**PLAN REVIEW SHEET**

Petition #: RZP 2022-115

Address: 617 Tom Hunter Rd.

Request: R-17MF (CD)

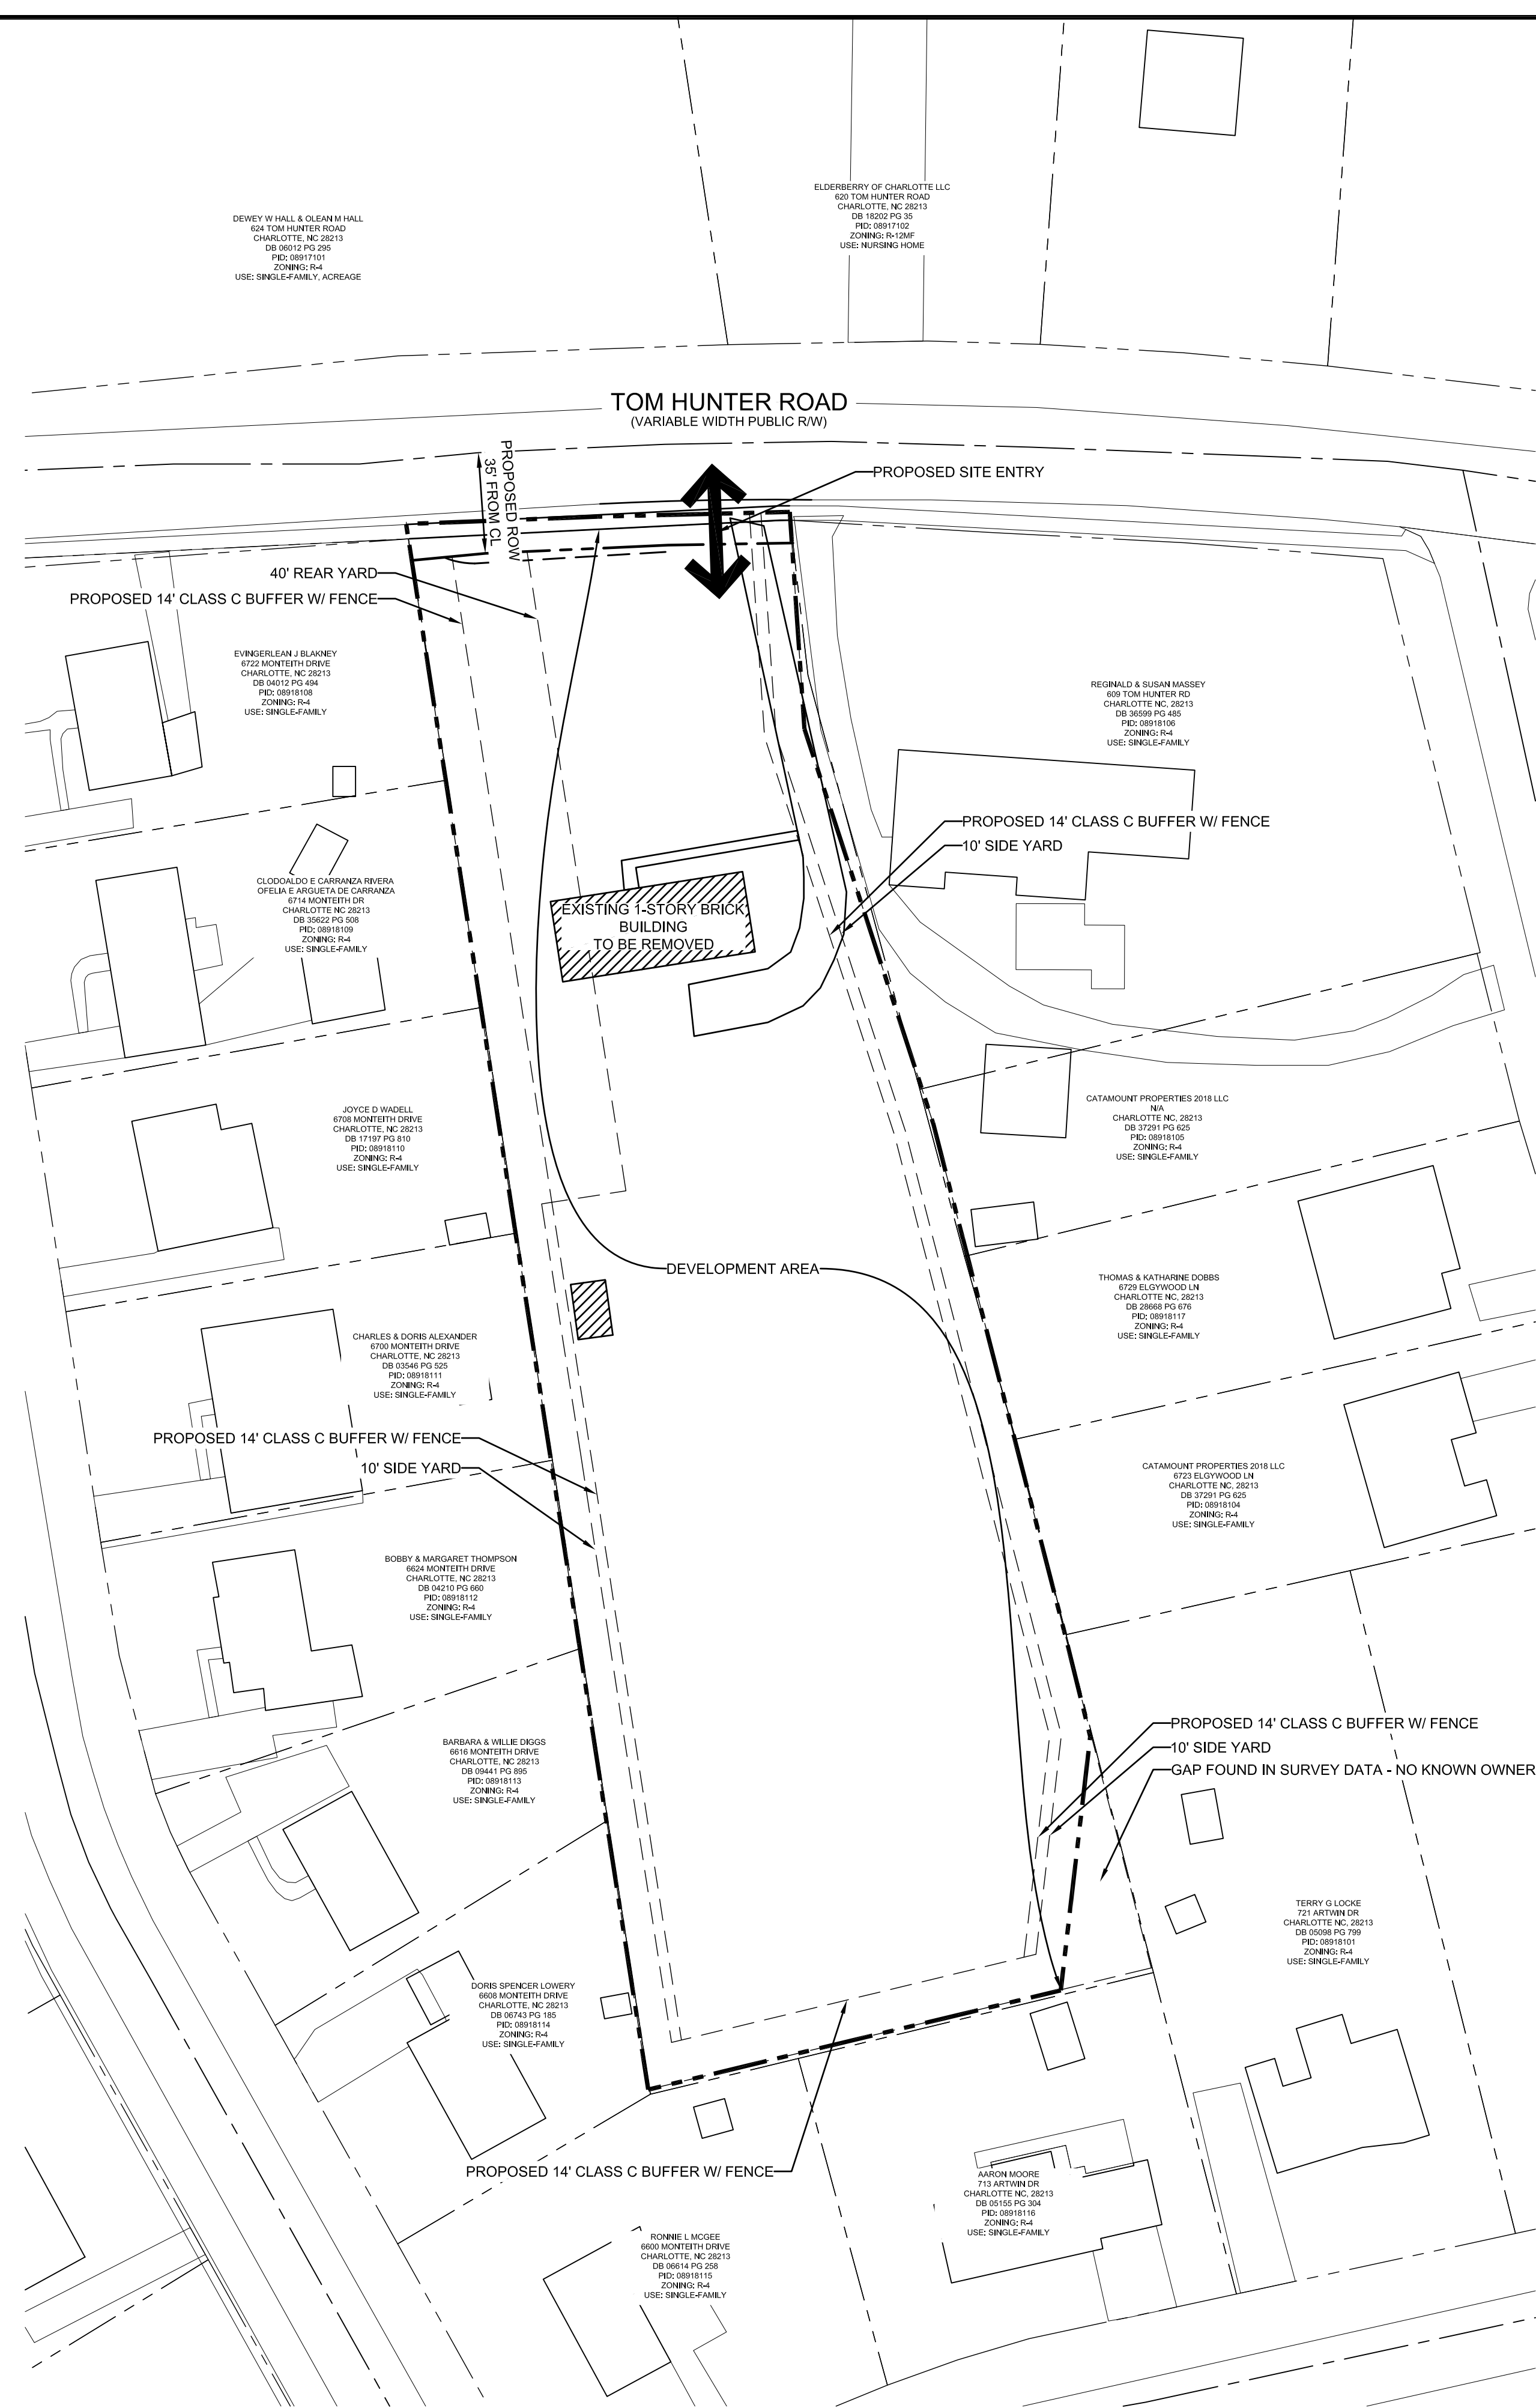
The site is located on CATS local bus route #211 along Tom Hunter Road. CATS requests the relocation of this stop to the far side of Monteith Drive and construction of ADA compliant bus stop type 60.01A. The final location will be determined during the Land Development plan review process.
